WELWYN HATFIELD ACCESS GROUP
 the common room
 ground floor
 ley house
 long ley
 welwyn garden city
 hertfordshire al7 2ex

re: Planning Applications Received by Welwyn Hatfield Council

Application No.	Description and Location	Applicant/Agent
N6/2014/1503/FP	Change of use from Sui-Generis to B2 (general industrial). 29 Burrowfield Welwyn Garden City AL7 4SS	Mr S Griffiths South Mimms Travel Limited 29 Burrowfield Welwyn Garden City AL7 4SS

Drawing No 2 : MGE02072014

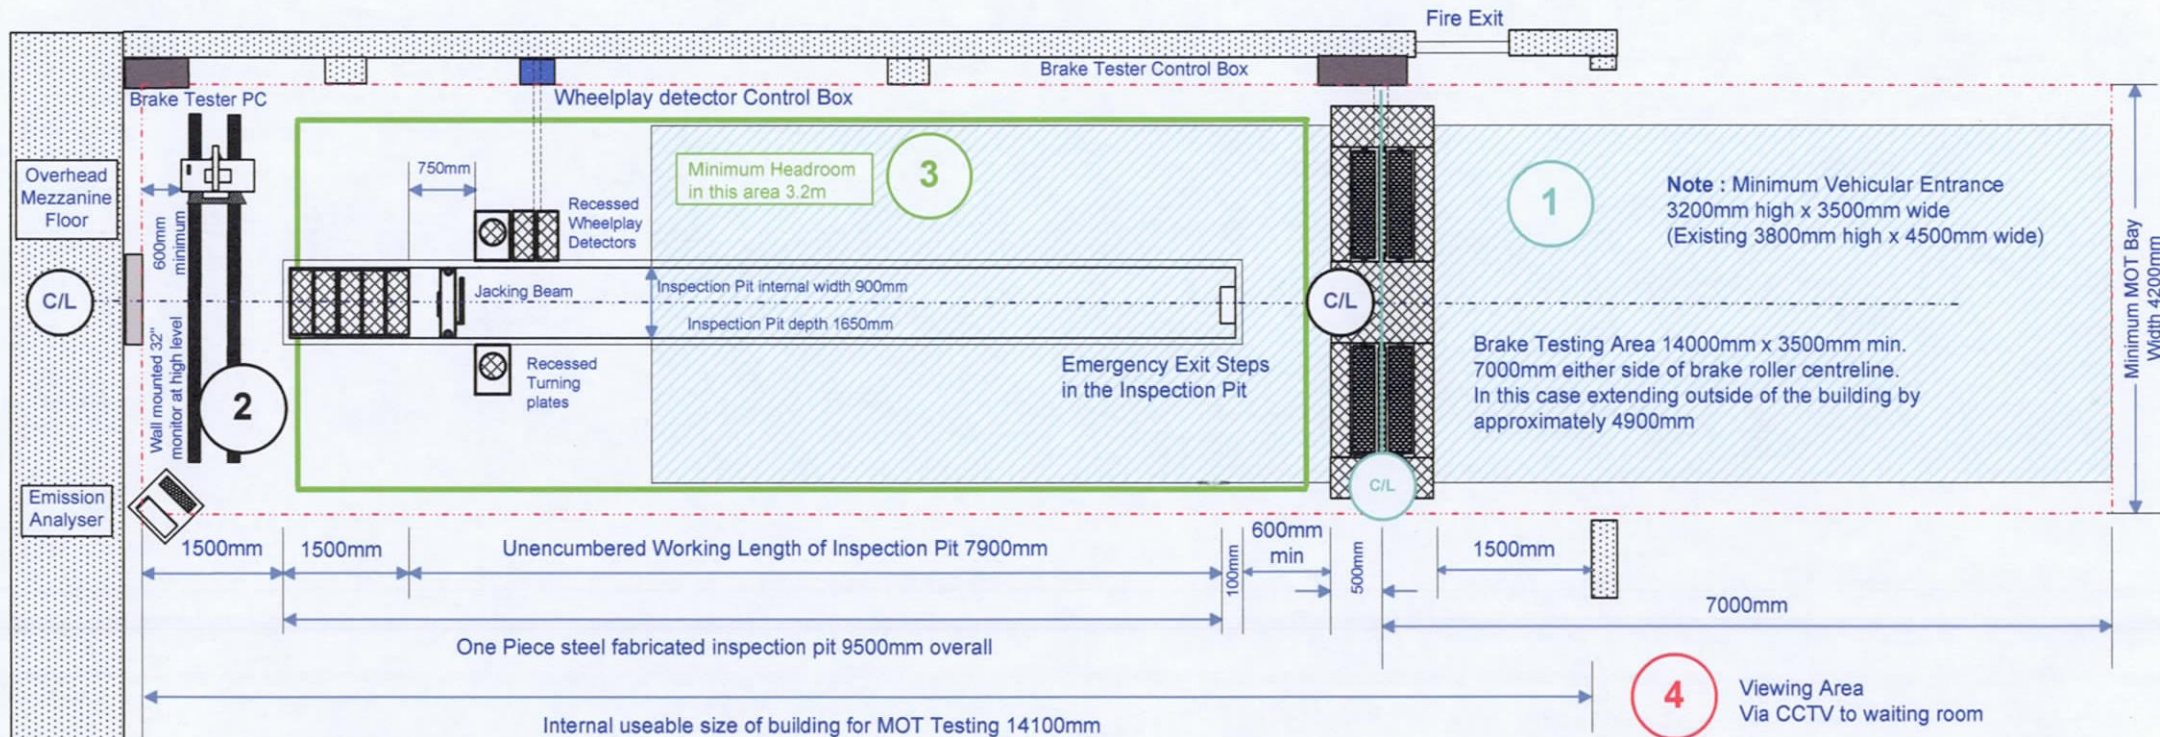
This drawing makes reference to 'Viewing Area via CCTV to waiting room'. Unfortunately, we are unable to identify from the drawing where the waiting room is located. Furthermore, we are unable to determine if a customer toilet is provided

Could you kindly provide answers to both these questions?
